STATE OF NORTH CAROLINA
DEPARTMENT OF TRANSPORTATION

December 20, 2019

Subject: **Modification Request for Section 404 Individual Permit, Section 401 Water Quality Certification and Neuse Riparian Buffer Authorization** for Interstate 40 Widening and Improvements from I-440/US 64 (Exit 301) to just north of SR 1525 (Cornwallis Road), including improvements to NC 42 and SR 1010 (Cleveland Road) in Wake and Johnston Counties, Federal Aid Project No. IMNHF-040-4(139)301; TIP Numbers I-5111 and I-4739, Divisions 4 & 5; Debit \$570 from WBS Element 42346.3.1.

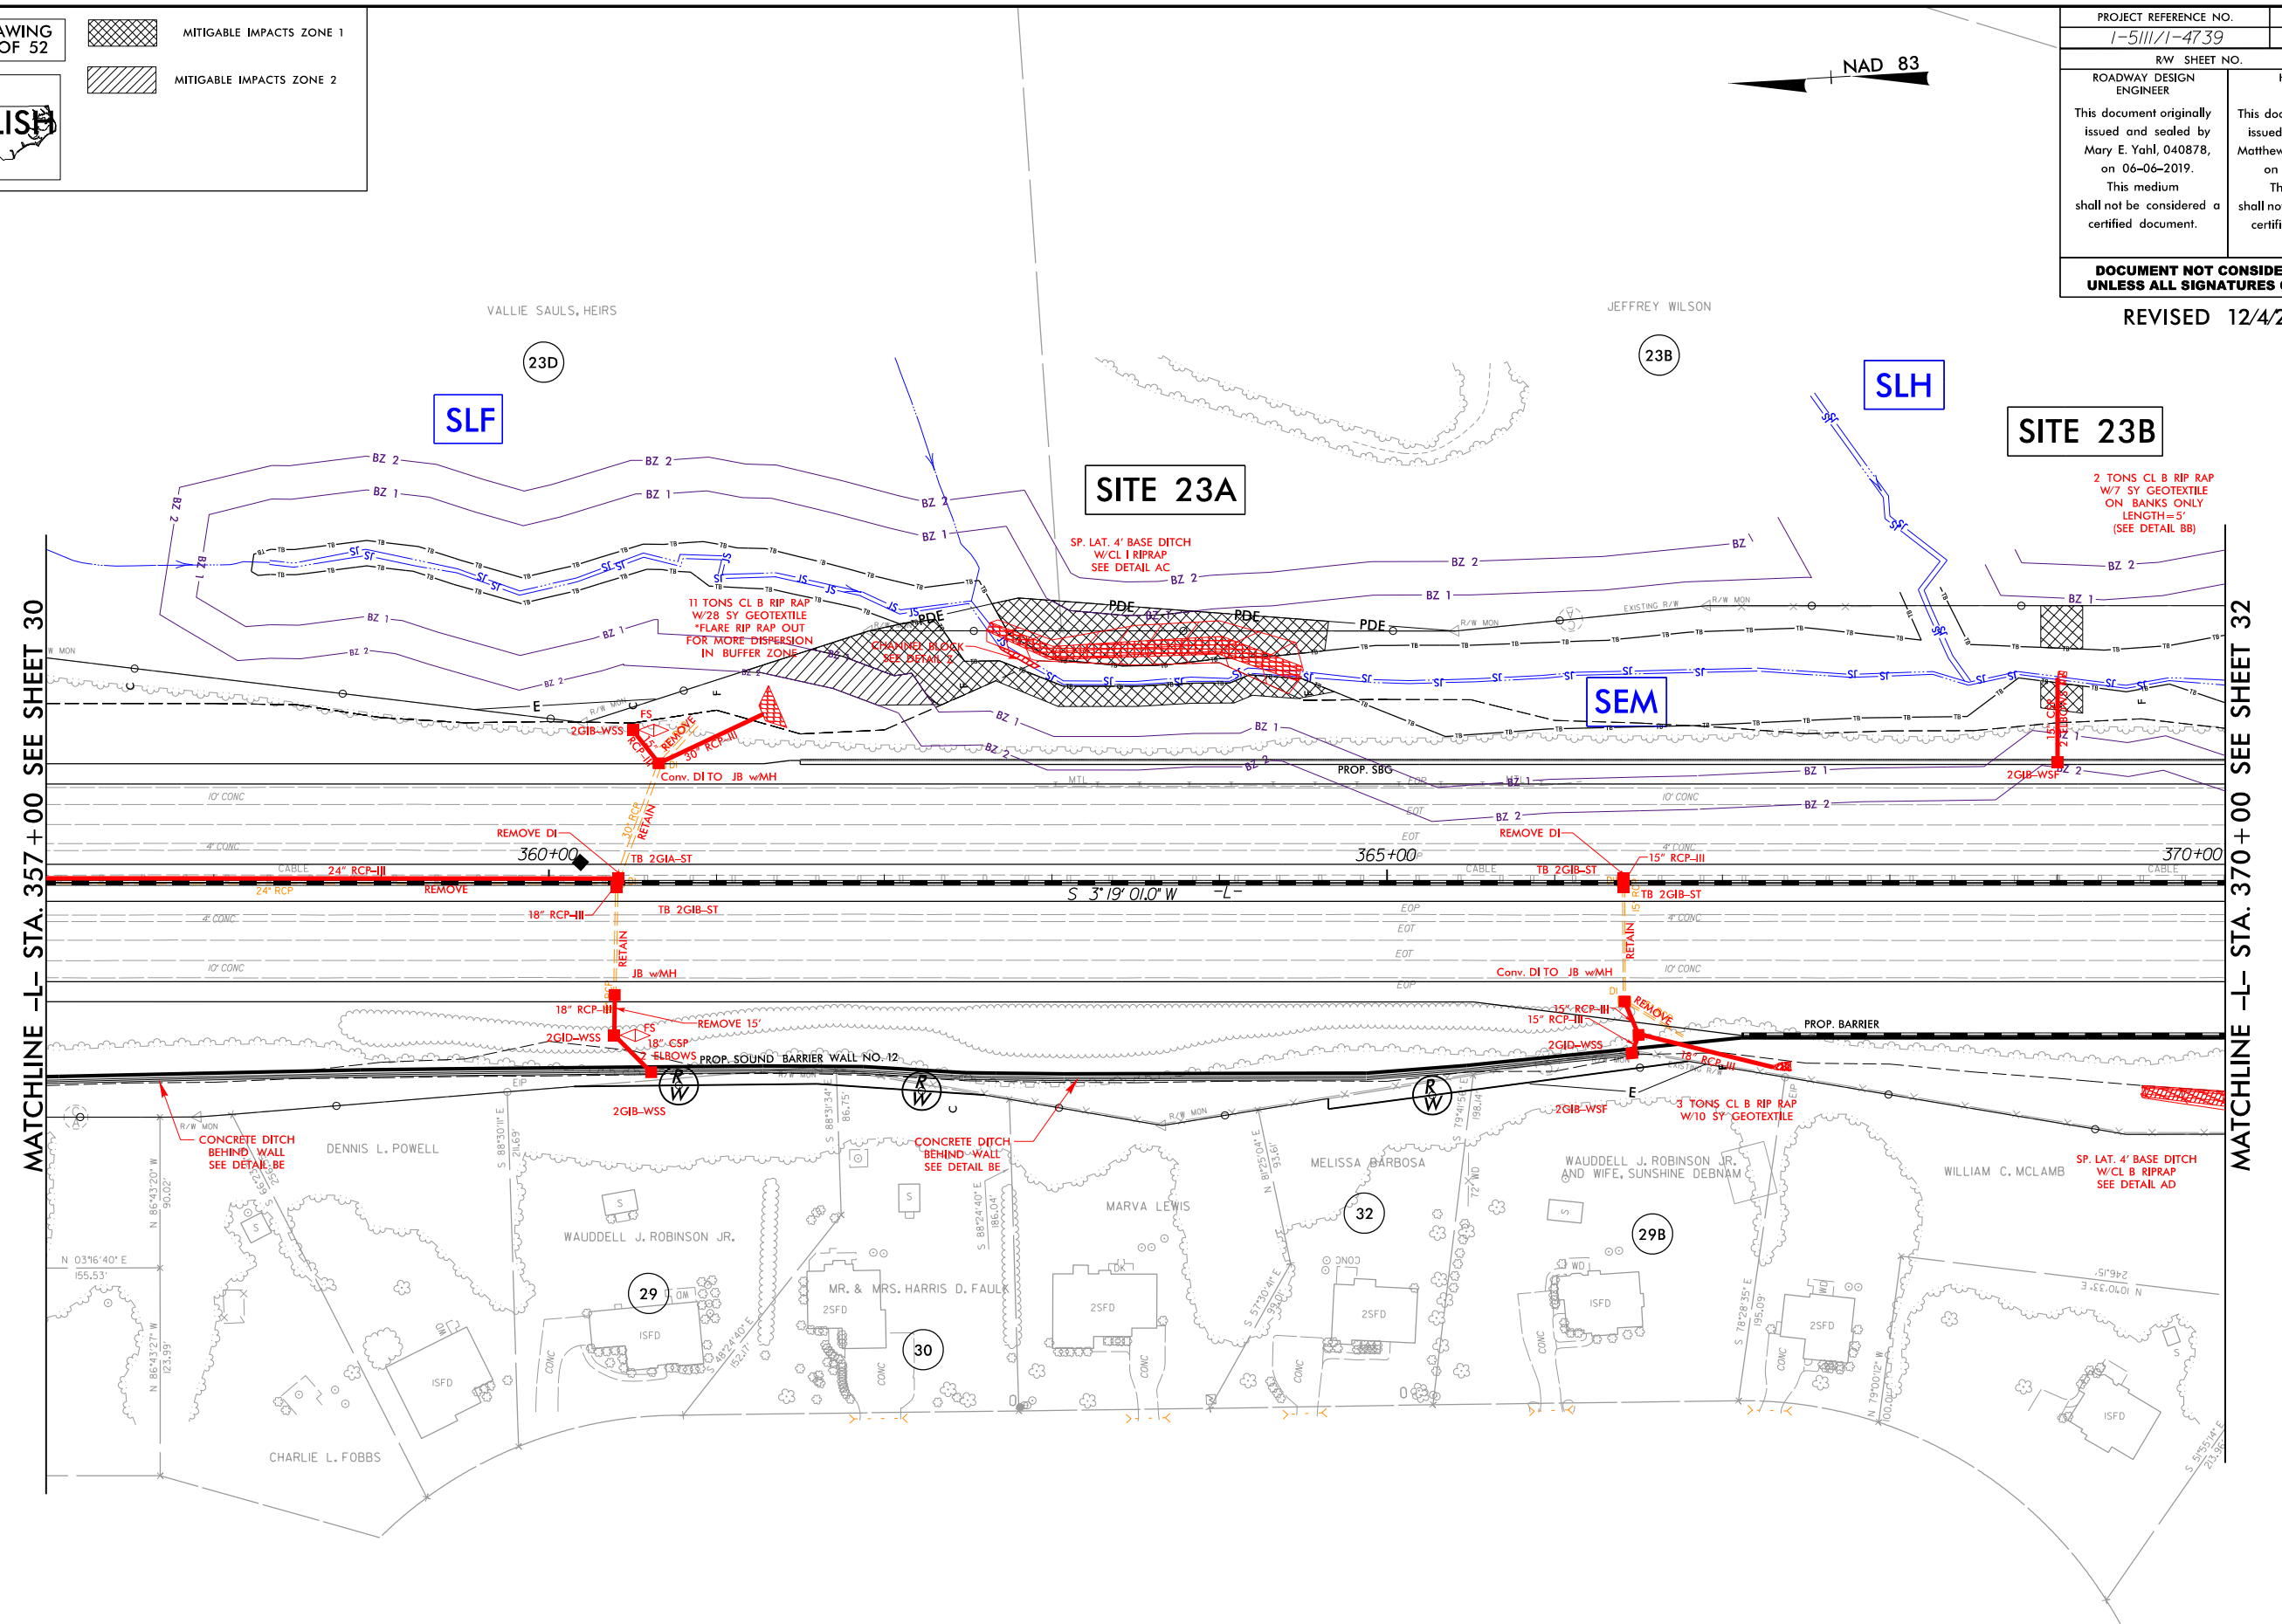
Specially for item 1, the buffer impacts, these revisions reflect additional impacts to mitigable Buffer Zone 1 areas following Division 5 staff field reviewing of the top of banks and edge of transportation facility areas at each location. The following sheets have been modified:

- Buffer drawing 1 of 52: titlesheet
- Buffer drawing 23 of 52: plansheet 31 reflecting revisions to Sites 23A and 23B
- Buffer drawing 24 of 52: plansheet 32 reflecting a revision to Sites 26A
- Buffer drawing 47 of 52: summary table
- Buffer drawing 51 of 52: summary table

- Site 23A: previous mitigable zone 1 impact total: 8,260 sq. ft.; new mitigable zone 1 impact total: 10,192 sq. ft. (difference of 1932 sq. ft.)
- Site 23B: previous mitigable zone 1 impact total: 635 sq. ft.; new mitigable zone 1 impact total: 1,037 sq. ft. (difference of 402 sq. ft.)
- Site 26A: previous mitigable zone 1 impact total: 233 sq. ft.; new mitigable zone 1 impact total: 422 sq. ft. (difference of 189 sq. ft.)
- Overall total project previous mitigable zone 1 impact total: 299,329 sq. ft.; new mitigable zone 1 impact total: 301,854 sq. ft. (difference of 2,525 sq. ft.)
